Recommendation Report for Planning Permission for Works or Extension to a Dwelling

REF NO: M/89/19/HH

LOCATION: 3 Sea Way
Middleton-On-Sea
PO22 7RZ

PROPOSAL: Front porch, enlarged dormer to rear and boarding to first floor elevations.

Drawing:
Elevations as proposed

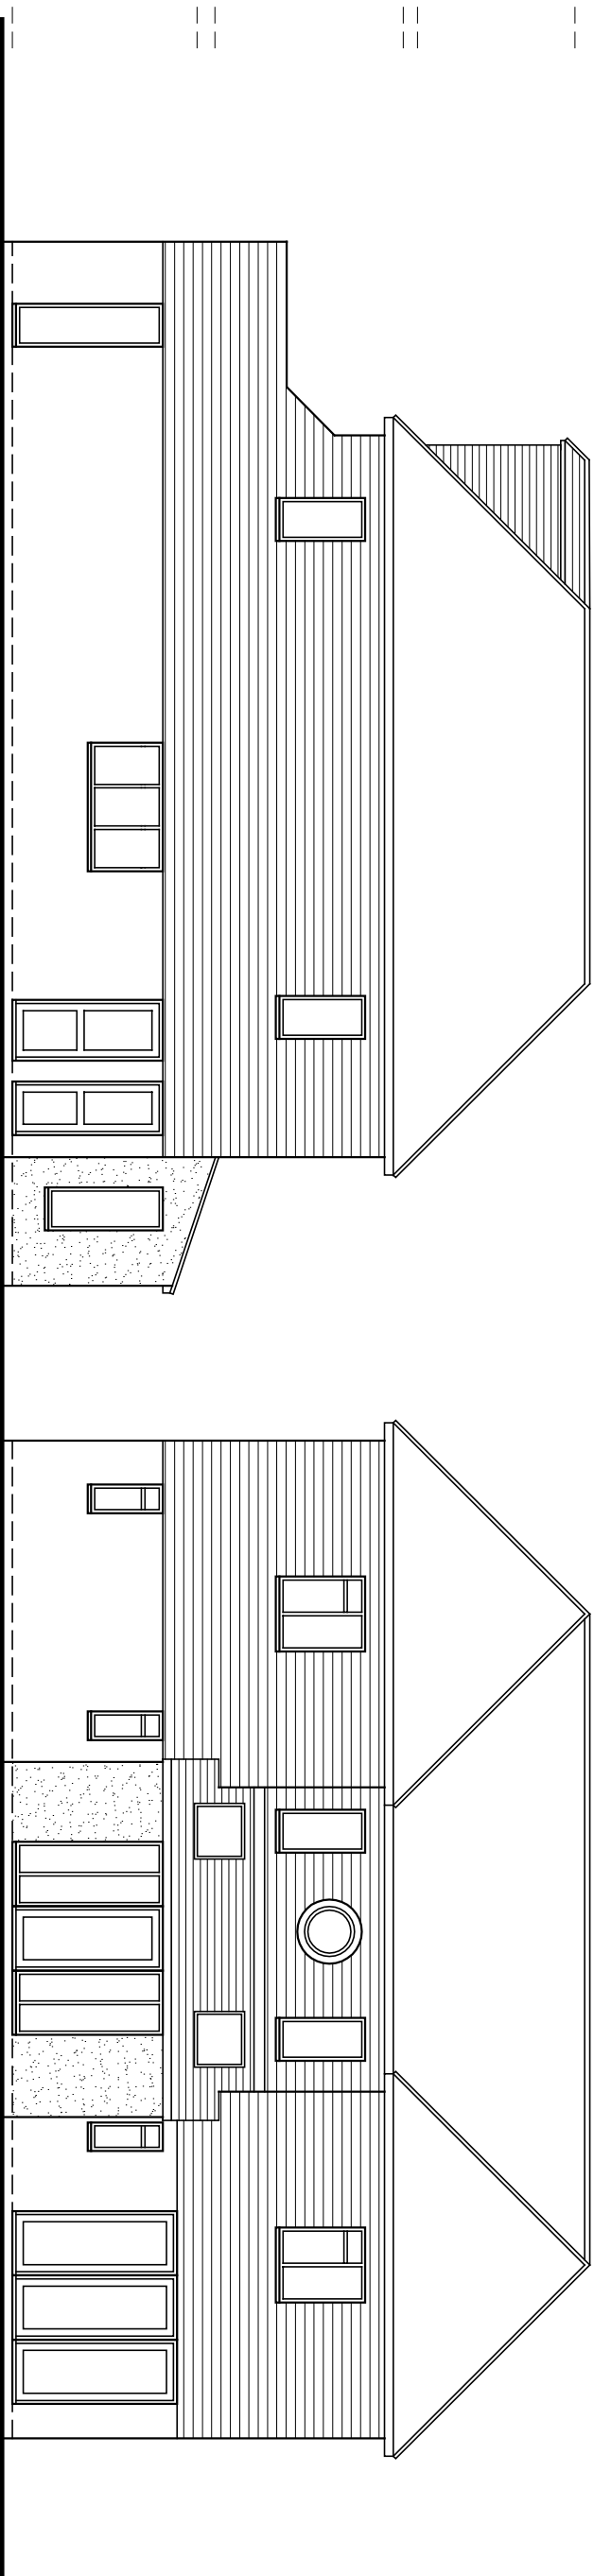
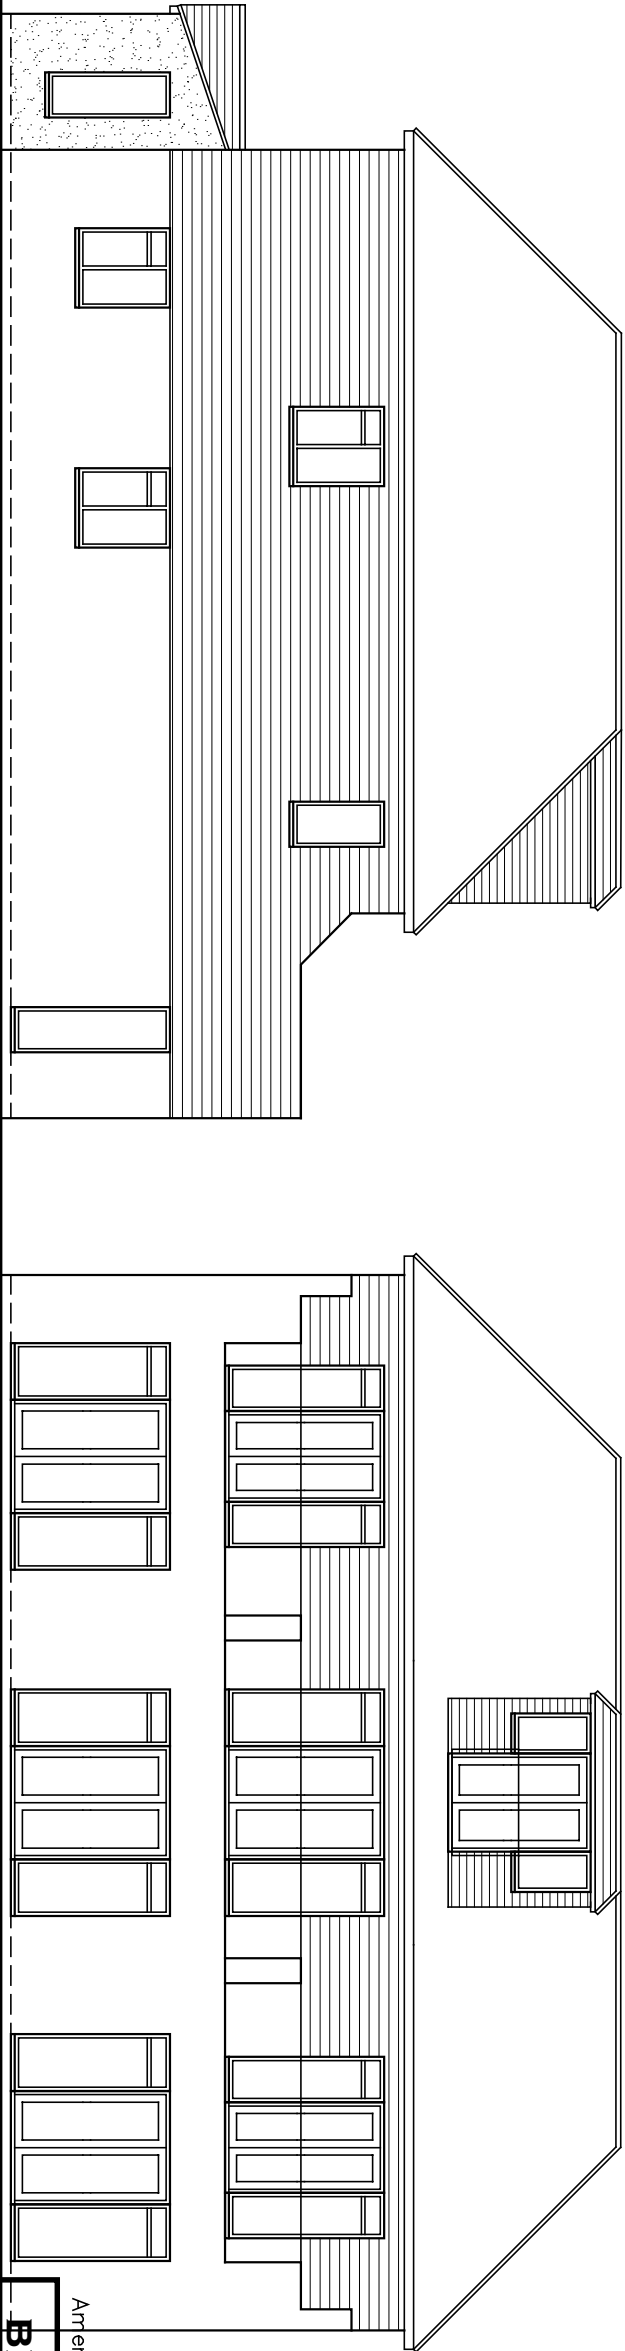
The proposed front porch is considered to result in a change in the appearance of the host dwelling, however, this change is not considered to be a harmful one. Due to the design and proposed materials of the porch, it is considered to be a sympathetic and subservient addition to the host dwelling. This can also be said for the proposed enlarged dormer, as whilst it meets the ridge height of the host dwelling, it is sited centrally along the rear roof slope of the dwelling, which is not considered to compromise the existing symmetry of the host dwelling.

The locality is host to a wide variety of dwelling styles, and types, with a range of materials present within the street scene of Sea Way. As such, the proposed cladding, in principle, is considered to be an acceptable addition to the host dwelling, in that it has no significantly harmful impact upon the character of the host dwelling, or its locality. However, due to the plans not specifying the colour of the proposed cladding, it will be conditioned that details be submitted to the Council.

- 3 No development above damp proof course (DPC) level shall take place unless and until a schedule of materials and finishes to be used for the proposed cladding of the building have been submitted to and approved by the Local Planning Authority and the materials so approved shall be used in the construction of the proposed development.
